Date: 21st October 2021

Our Ref: AB/113/21/DOC

Town & Country Planning Act 1990 (as amended)
Town and Country Planning (Development Management Procedure) (England) Order 2015
Approval of details reserved by condition imposed under AB/39/18/PL relating to conditions 3-4-5
Construction Management Plan, 4-surface water drainage & 5-foul & surface water sewerage disposal.
30 Ellis Close Arundel BN18 9LG

Arun District Council have decided to **REFUSE** details reserved by condition for the following reasons:

Drawing Status	FOR APPROVAL		
Client	Arun District Council		
Project	S247 Stopping Up		
Drawing Title	Ellis Close, Arundel, BN18 9LG		
Scale	1:200	Date	08/07/21
Drawn By	MJA	Checked By	MJA
Drawing No.	D1955-203		Rev. B

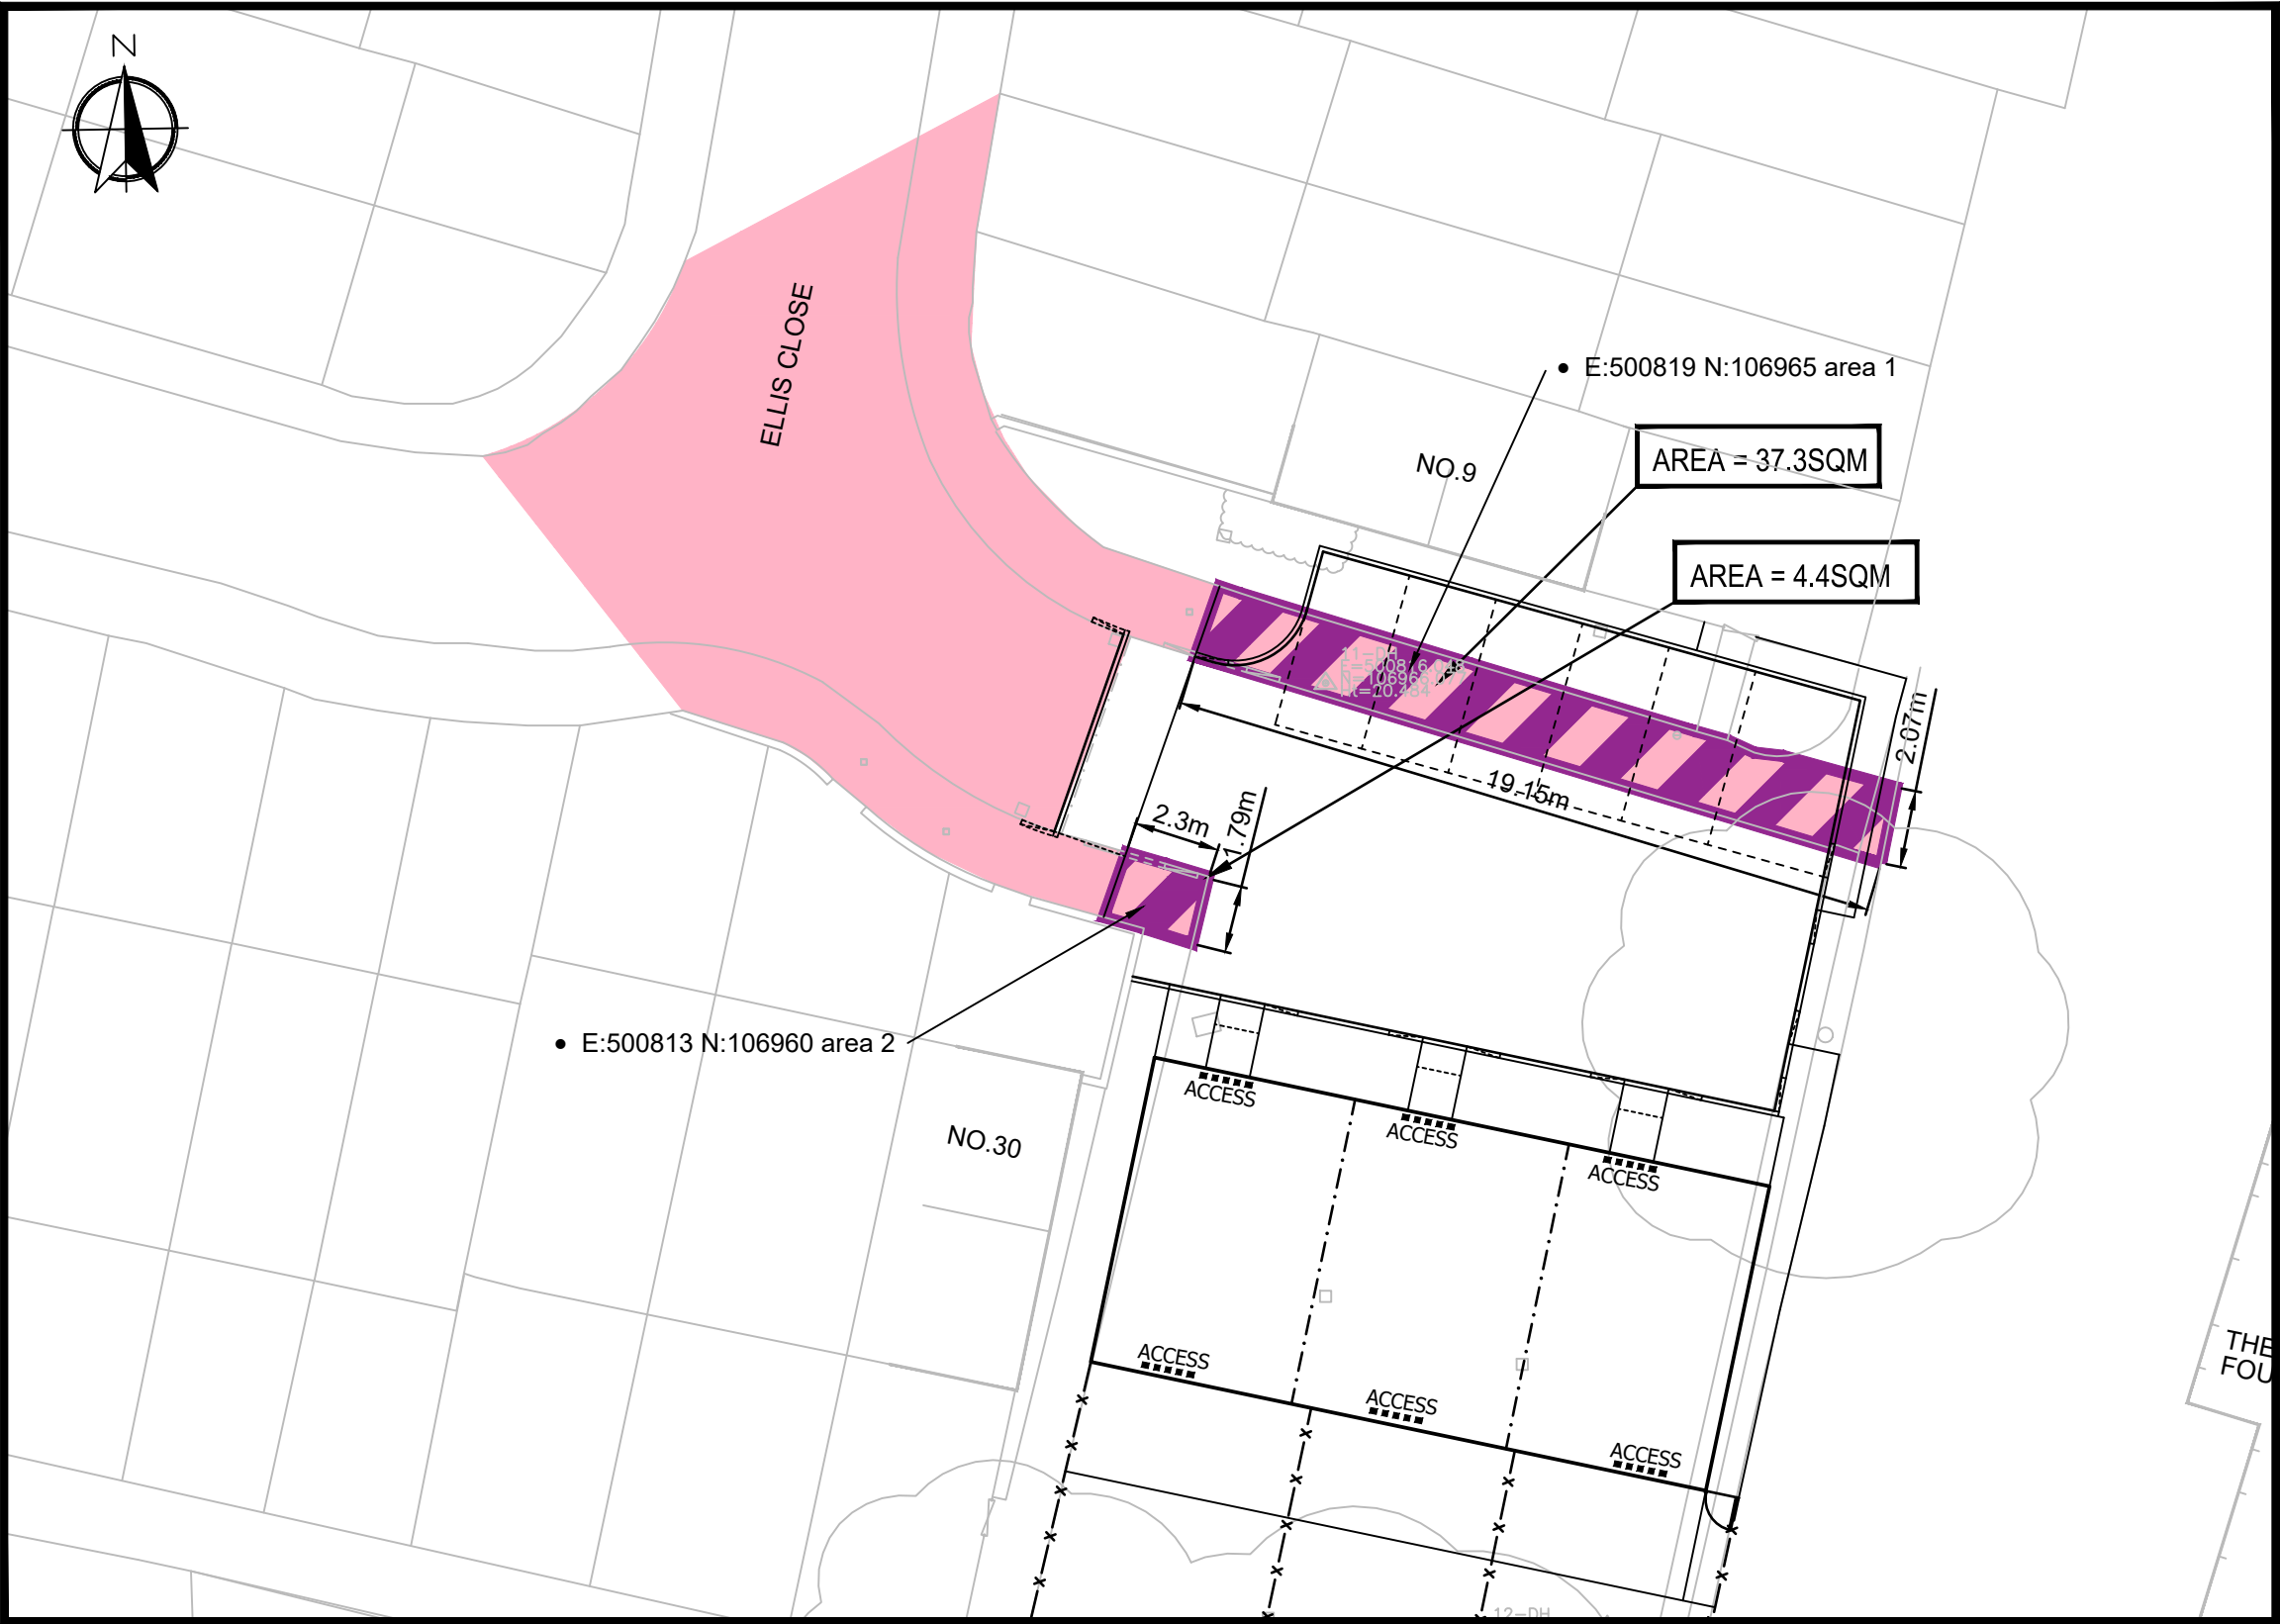
The location of any heras fencing / hoarding should be made clear as part of the Construction and Environmental Management Plan, particularly given the intention to 'Stop Up' some sections of public highway, so that a suitable informative can be provided if the fencing will obstruct the public highway.

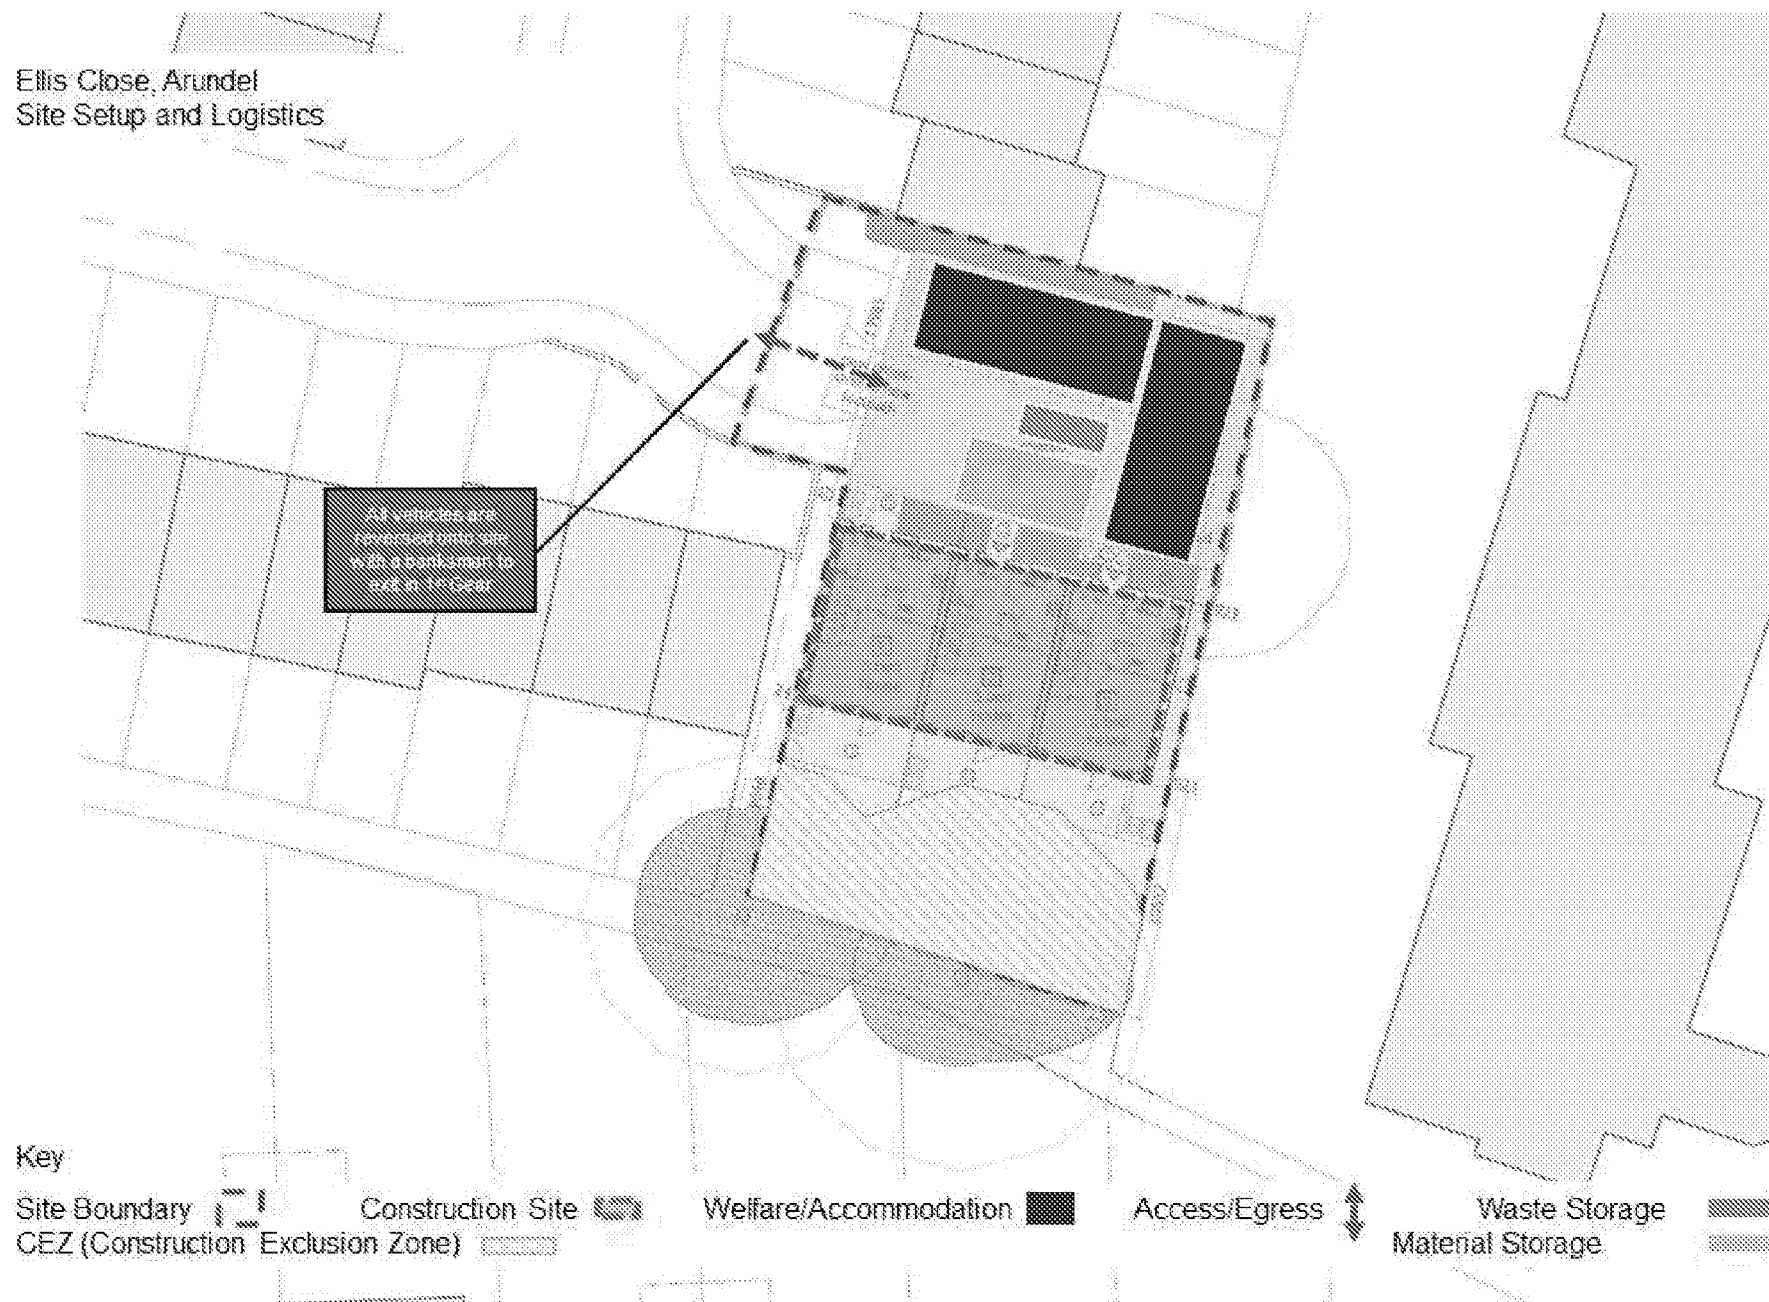
This condition cannot be discharged based on the information submitted to date. The Construction and Environmental Management Plan details the construction site. It is not clear if all of these areas will be enclosed with heras fencing / hoarding.
